**Subject: Request for Modification to the Section 404 Individual Permit and Section 401 Water Quality Certification for I-485 (Charlotte Outer Loop) from east of I-77 to I-85 in Mecklenburg County. Division 10, TIP's R-2248 E and R-2123 CE, Debit \$570 from WBS 34410.3.GV2**

**Reference: USACE Individual Permit Action ID SAW-2011-01237, dated Nov.22, 2011.  
NCDWQ Water Quality Certification No. 003868, dated October 14, 2011.**

**R-2248 E – Roadway Portion of Future I-485 between I-85 and NC 115**

Permit Drawing  
Sheet 48 of 108

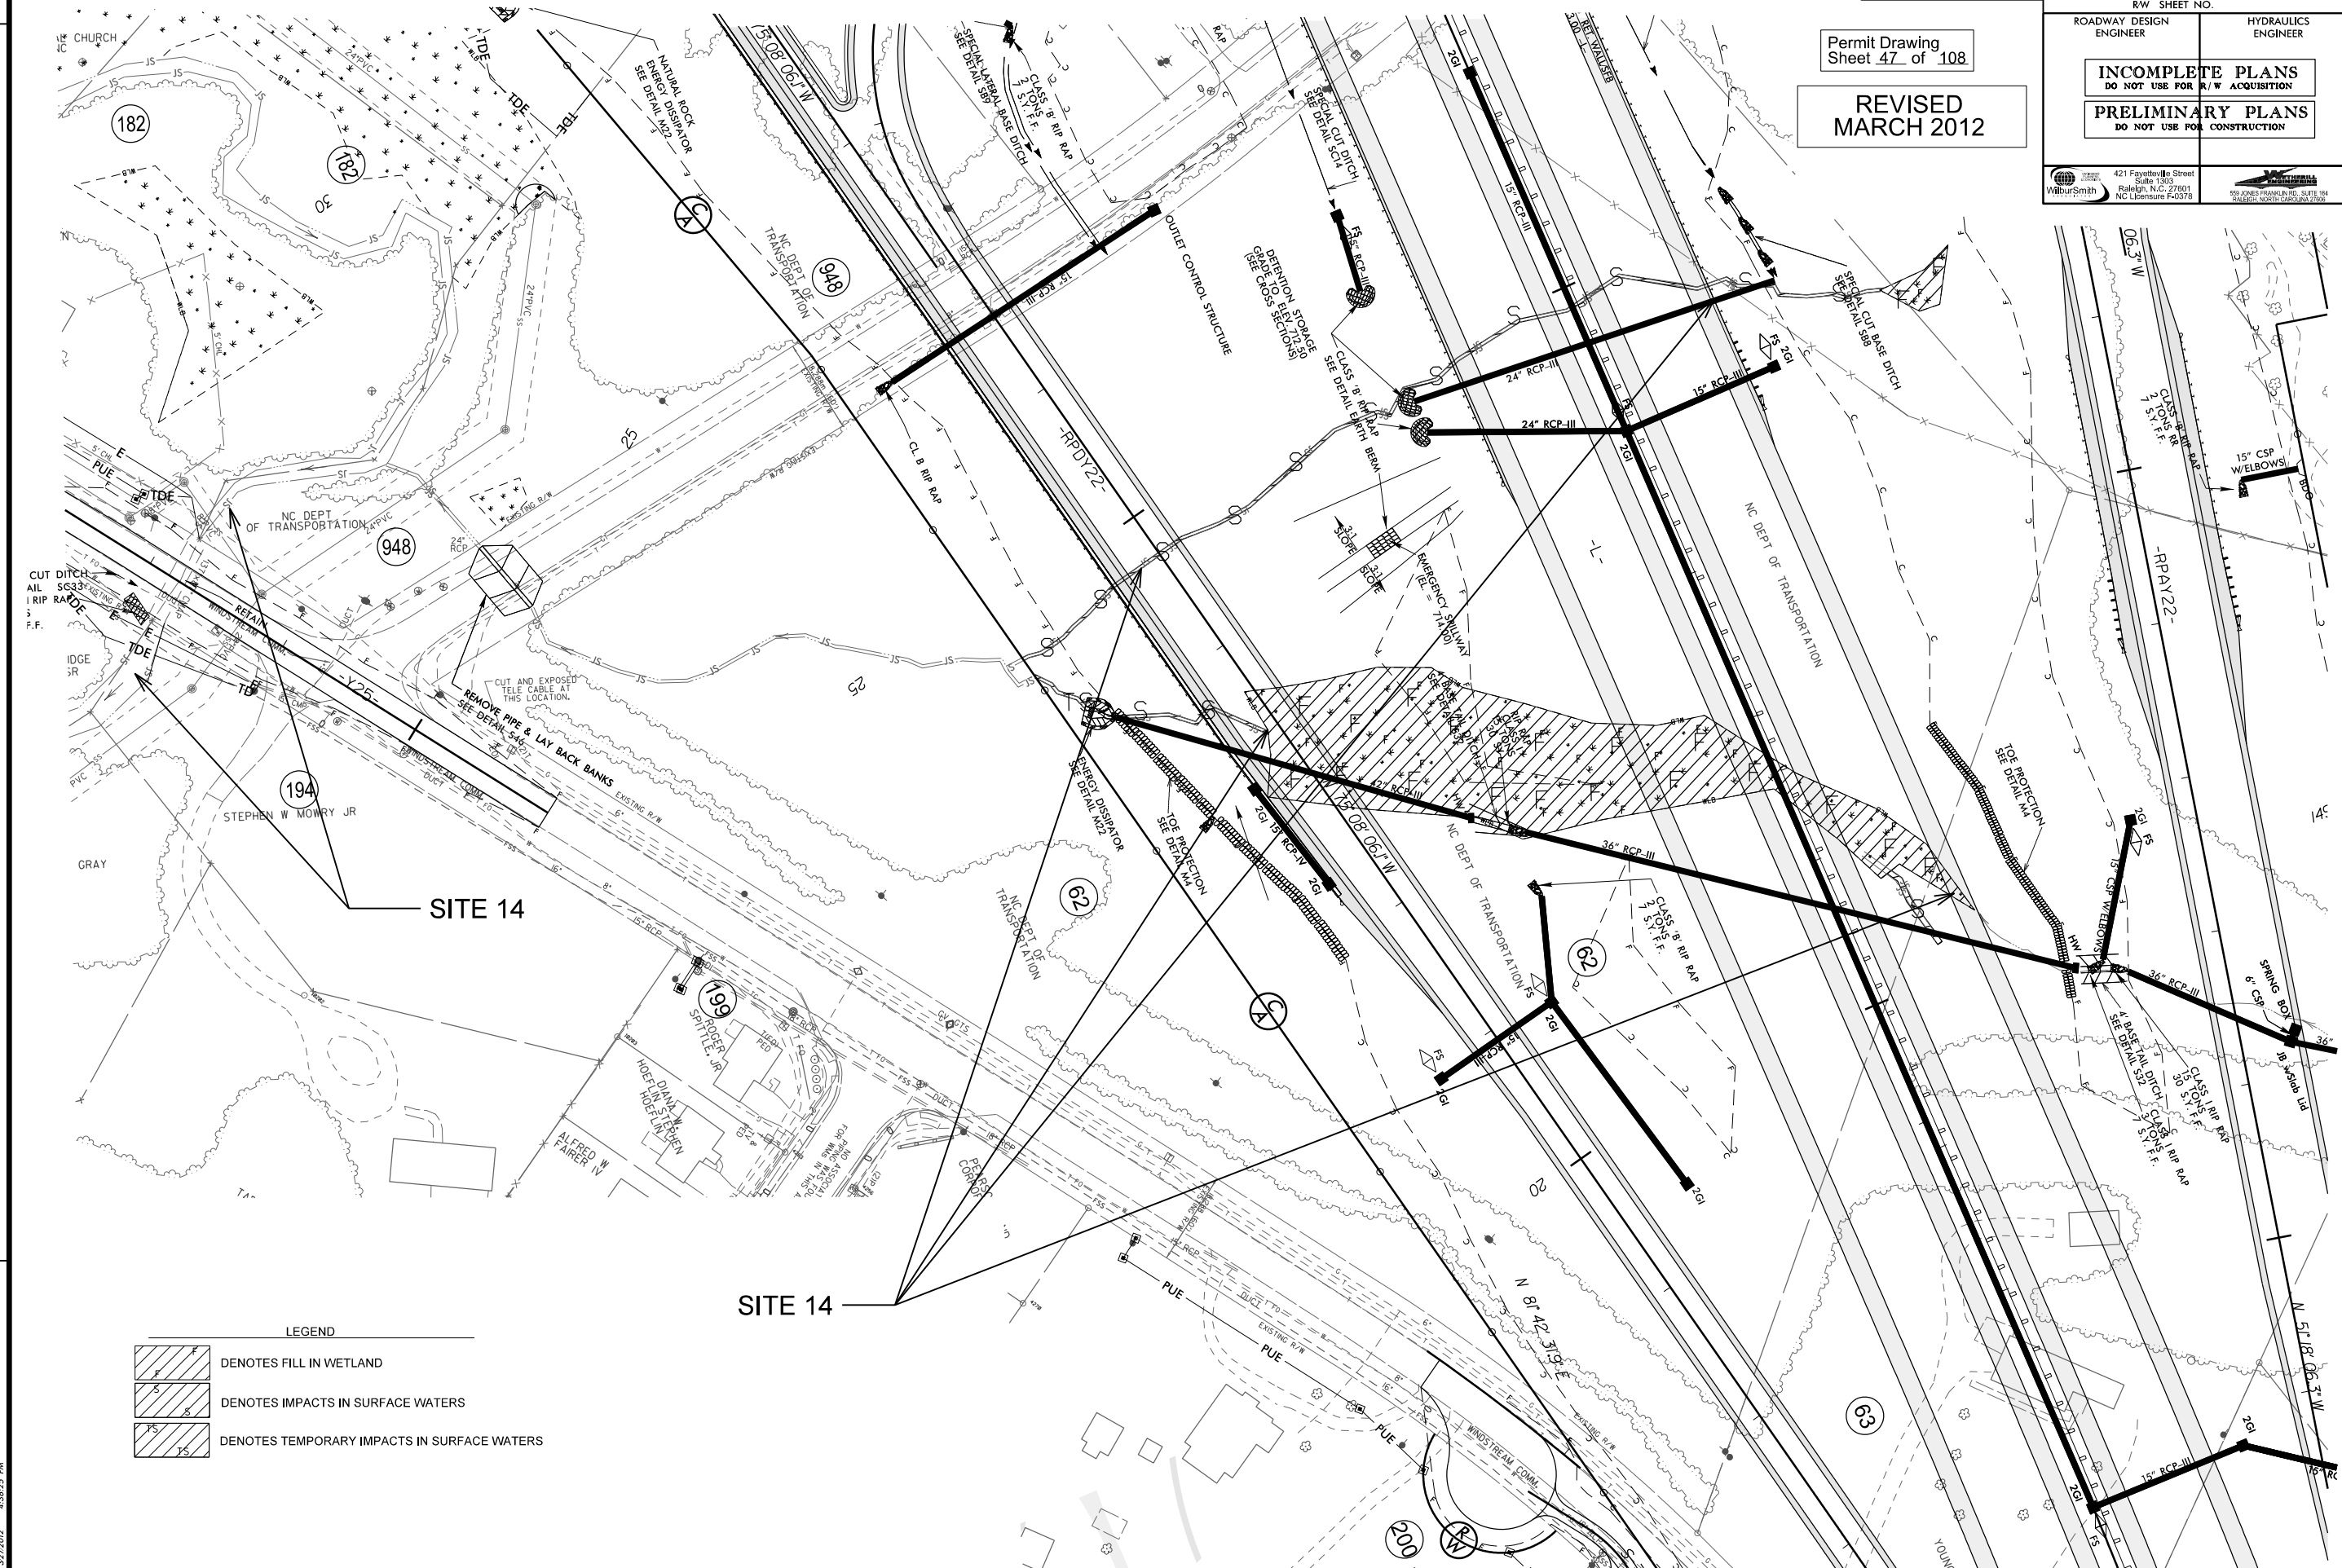
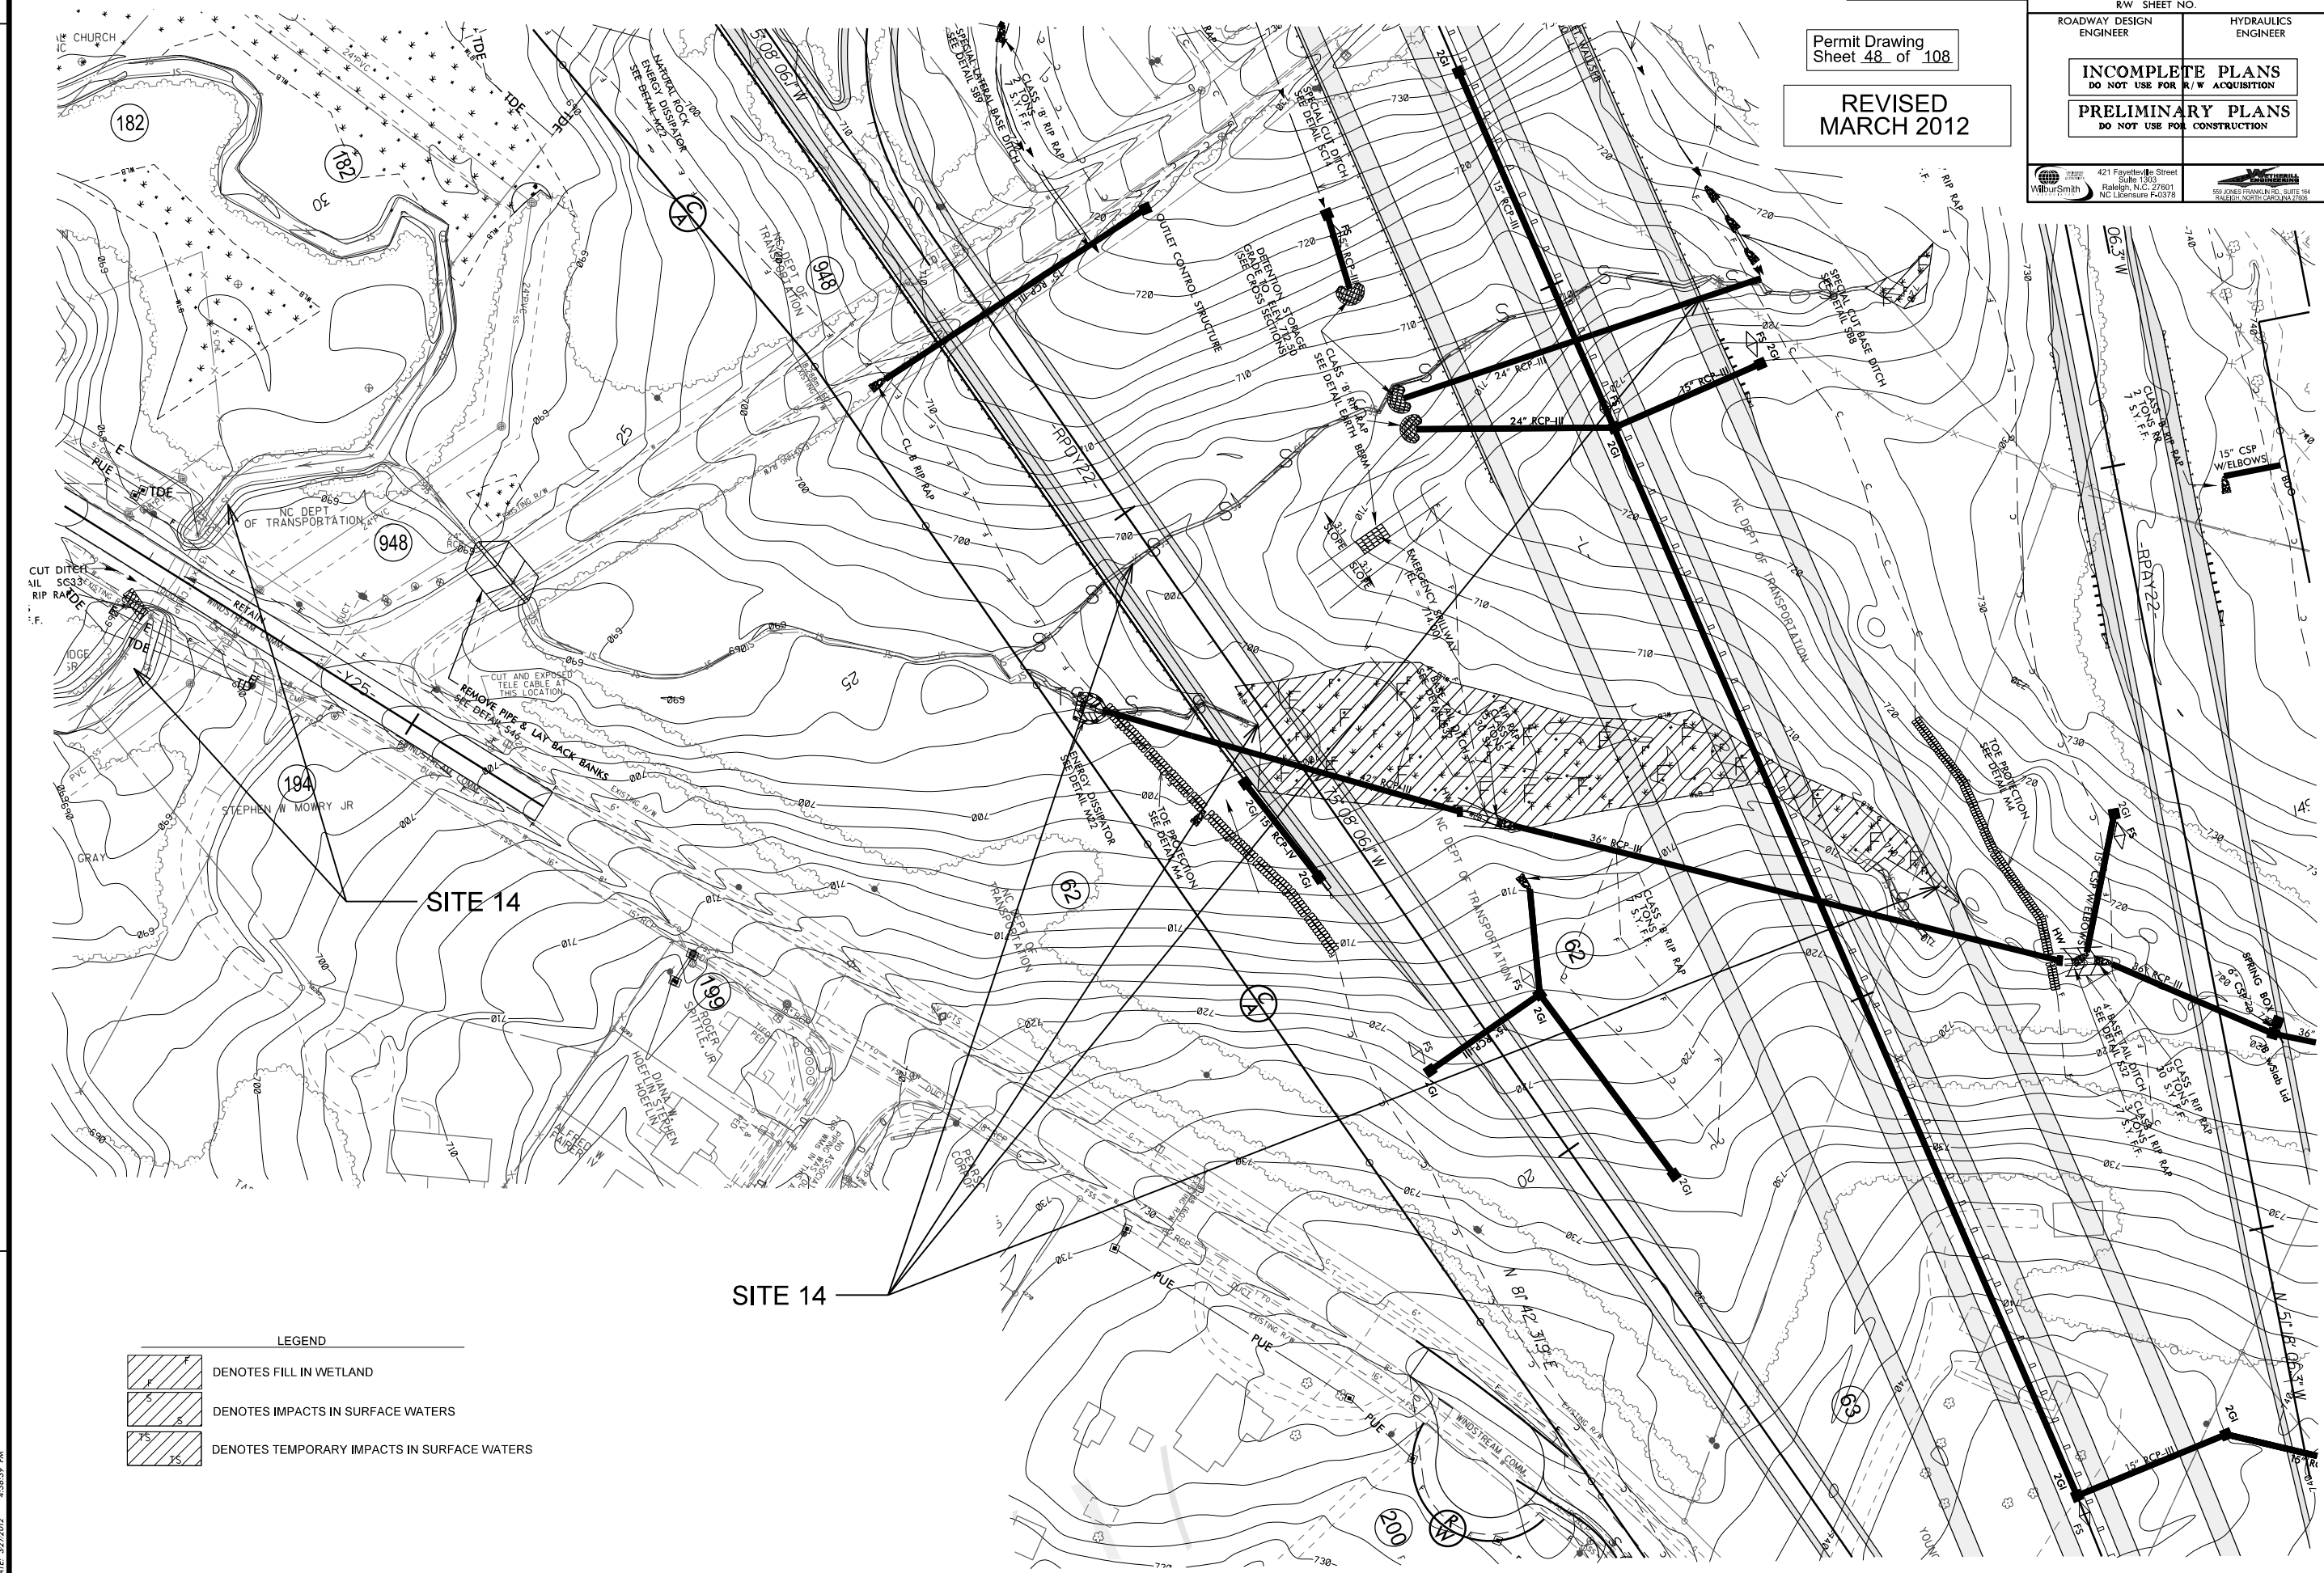
**Revision:** Elimination of 2 @ 7' x 8' RCBC at S11/Mallard Creek Road.

**Reason:** The project no longer includes this stream crossing.

**Impacts:** Elimination of the 2 @ 7' x 8' RCBC at S11/Mallard Creek Road will result in a decrease of 0.02 acre of permanent fill in wetlands, a decrease of 35 feet from bank stabilization and a decrease of 0.01 acre of temporary stream impacts.
